Application for approval of details reserved by condition 5 & 6 of previously approved
planning application LU/350/11
Millfield Rest Home 9 St Catherines Road Littlehampton

SUBJECT: LU/32/12/DOC - Application for approval of details reserved by
condition 5 & 6 of previously approved LU/350/11.

Millfield Rest Home, 9, St Catherines Road, Littlehampton, West Sussex,
BN17 6HS

Proposed parking for cycles AND MOTOR VEHICLES

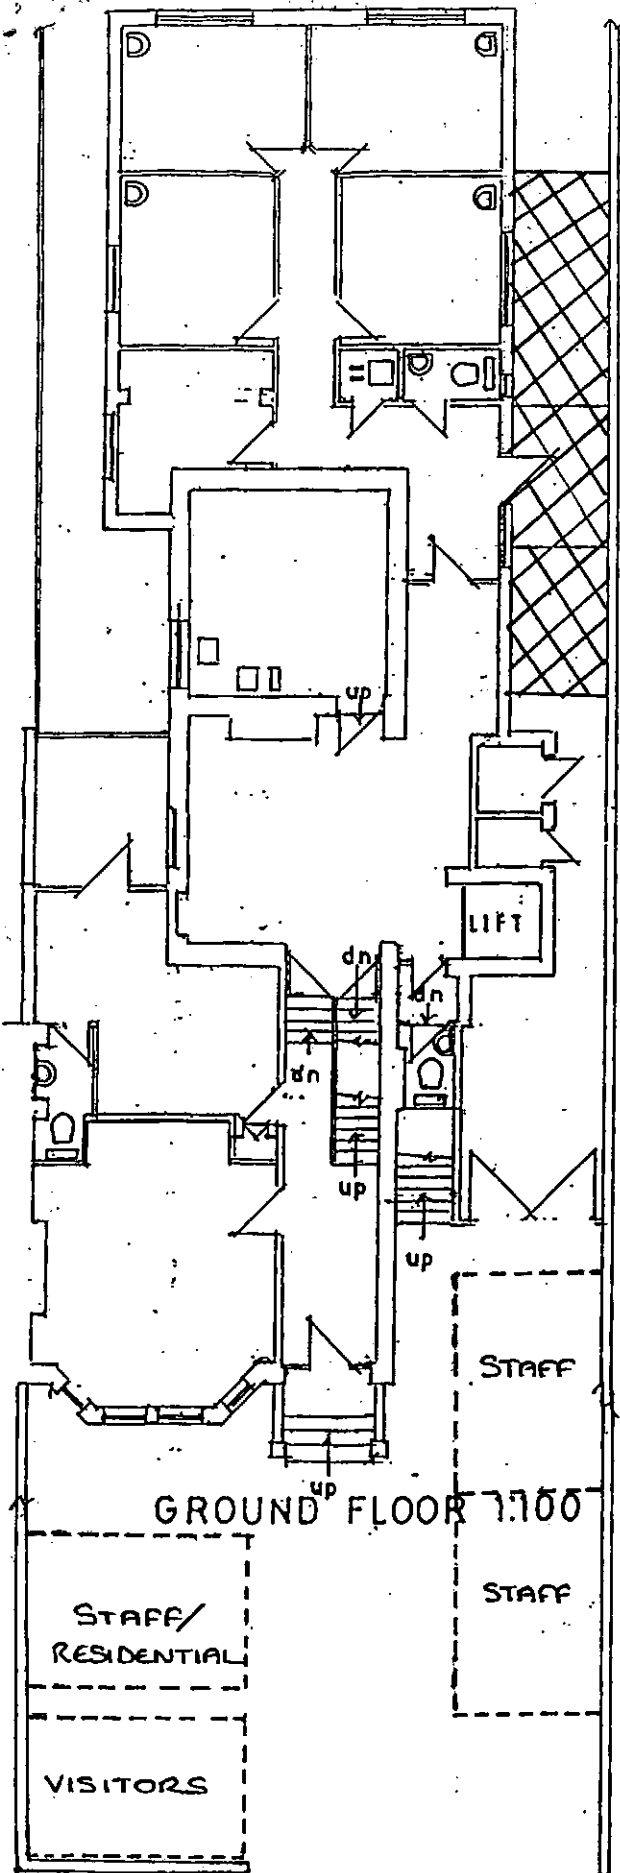
The applicant has supplied a plan and photographic evidence identifying a covered space within the curtilage of the property that can be used for cycle parking. It would appear that this area is secured by gates at both the front and rear access to the property. Current WSCC cycle parking standards would require enough space to store four cycles (two each for the residential and office elements of this development), and from measuring the plans provided the area is considered to be an appropriate size.

The applicant has supplied a plan and photographic evidence detailing the proposed parking layout, which allows for four spaces (1 x Visitor, 1 x Residential / Staff, 2 x Staff). I can confirm that the quantity of parking spaces is inline with current WSCC parking standards for a development mix of this type in this location. From inspection of the plan provided the proposed parking layout would not appear to be ideal as the layout could result in vehicles having to be moved to allow others to exit the site. However the site does benefit from a wide open access with good vehicular and pedestrian visibility so this manoeuvring would not be considered detrimental to highway safety. The applicant may wish to consider the removal of one of the ?staff? vehicular parking spaces to allow for more convenient manoeuvring on site, I can confirm that providing three vehicular parking spaces for this development would also be considered appropriate. I would highlight that the removal of one on site car parking space may increase the demand of on-street parking. The allocation of the parking spaces also appears to be appropriate. From the information I have before me there would be no highway concerns raised from the discharge of conditions 5 and 6 of planning approval LU/350/11.
